CITY OF ALBUQUERQUE

October 17, 2024

**RE: Presbyterian Hospital Hybrid O.R.
1100 Central Ave. SE
Grading and Drainage Plans
Engineer's Stamp Date: 10/07/2024
Hydrology File: K15D005A1**

Based upon the information provided in your submittal received 10/07/2024, the Grading & Drainage Plan is not approved for Building Permit and Grading Permit. The following comments need to be addressed for approval of the above referenced project:

EXISTING AND PROPOSED DMP

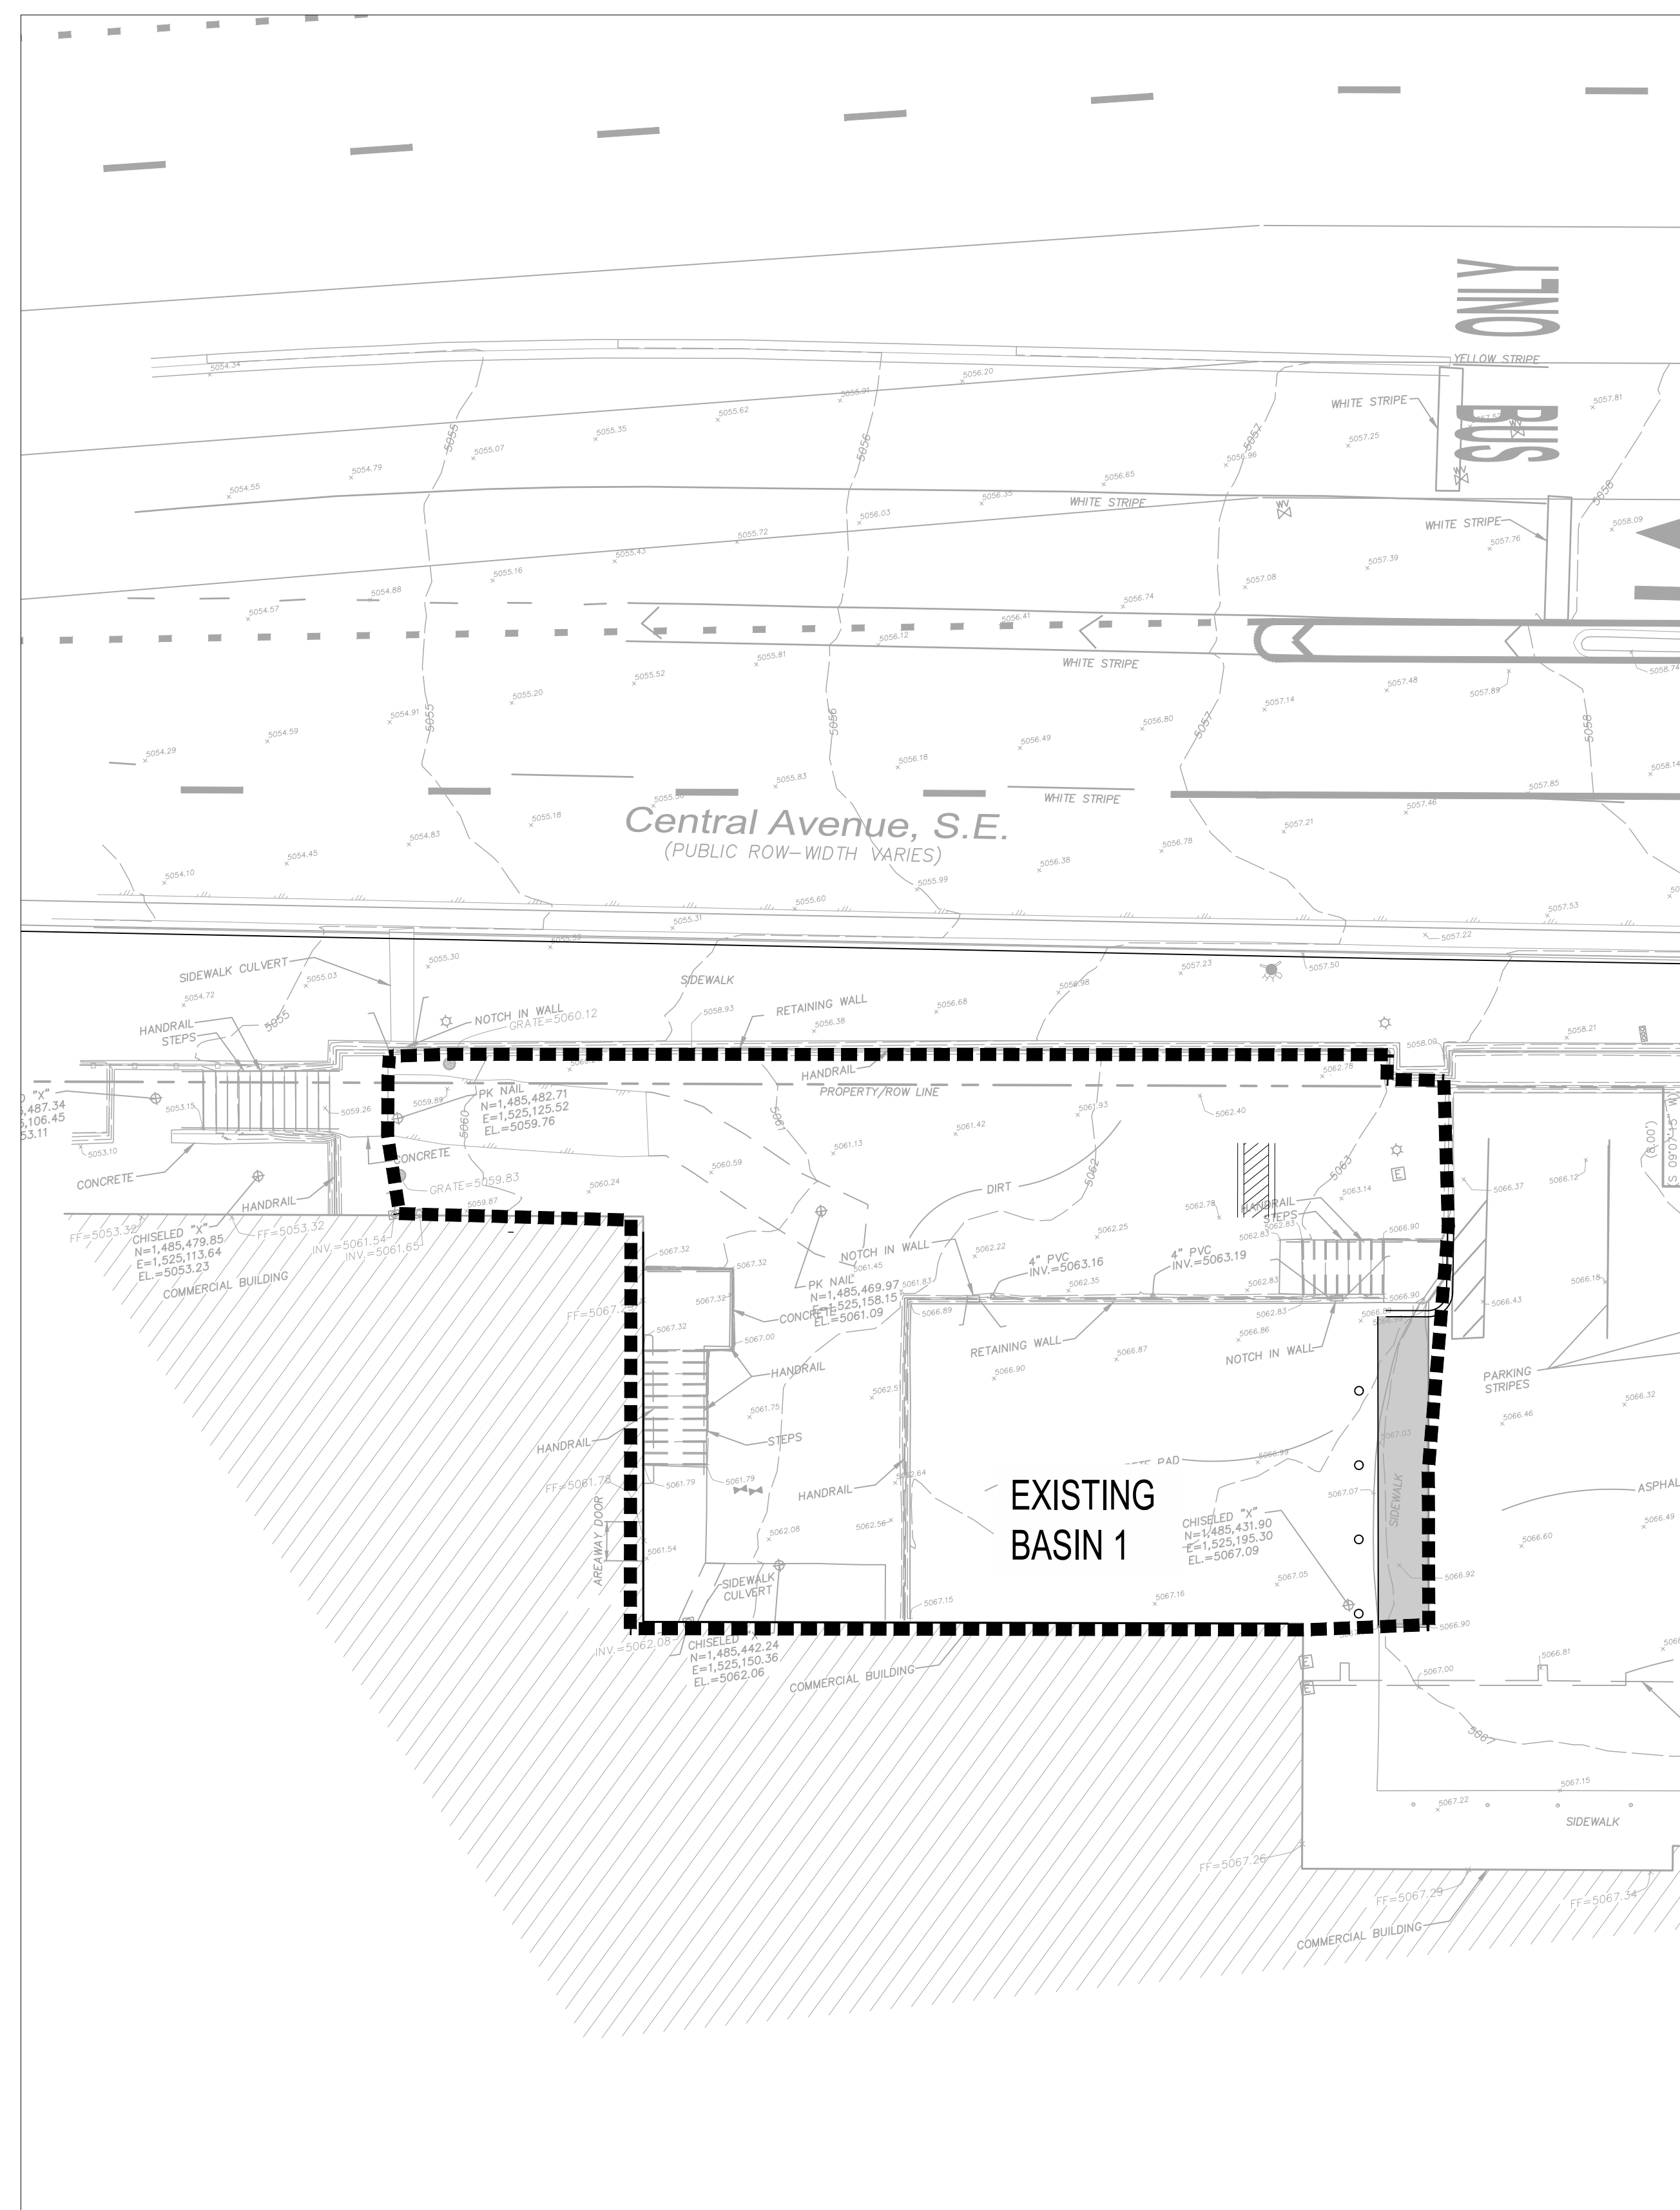
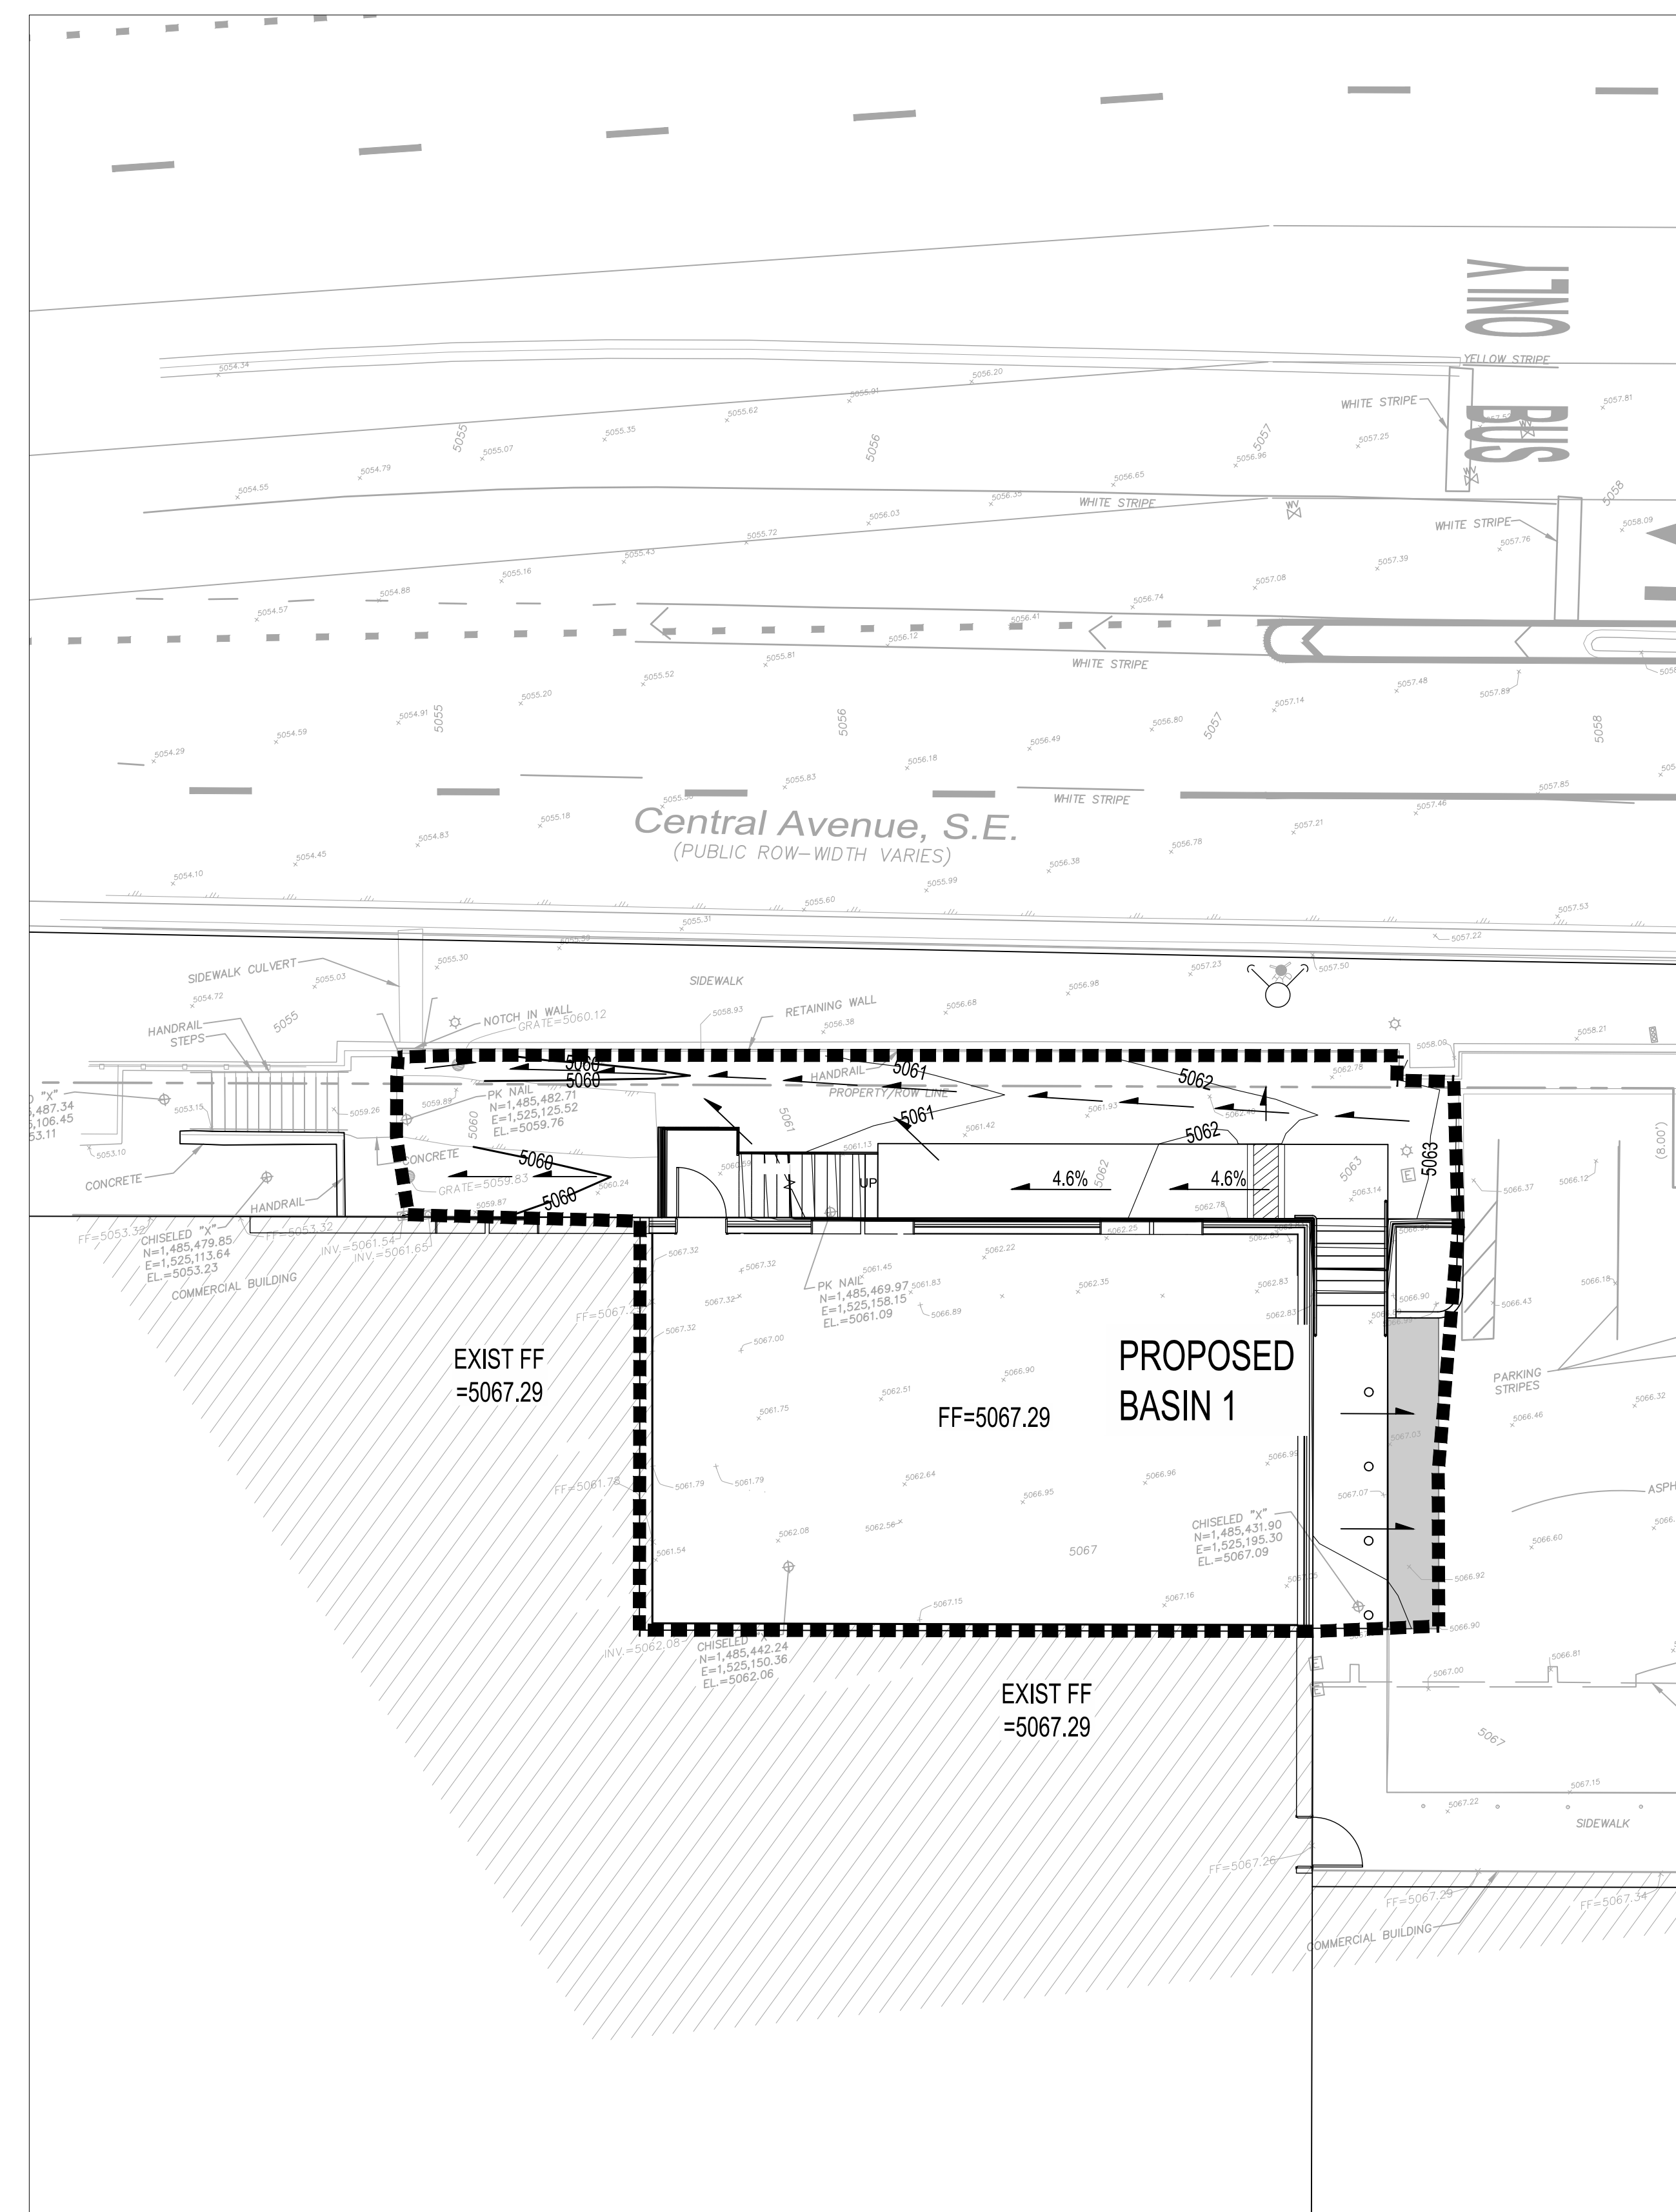
1. Please complete the Payment-in-Lieu calculations and processing per DPM Part 6-12(C)(1) by emailing the appropriate Waiver Application from Stormwater Quality Volume Management On-site to PLNDRS@cabq.gov. Once this is received and approved, follow the instructions on the bottom of the form and pay it at the Treasury in Plaza de Sol, take three copies of the treasury deposit slip and include one copy of the paid deposit slip when resubmitting.
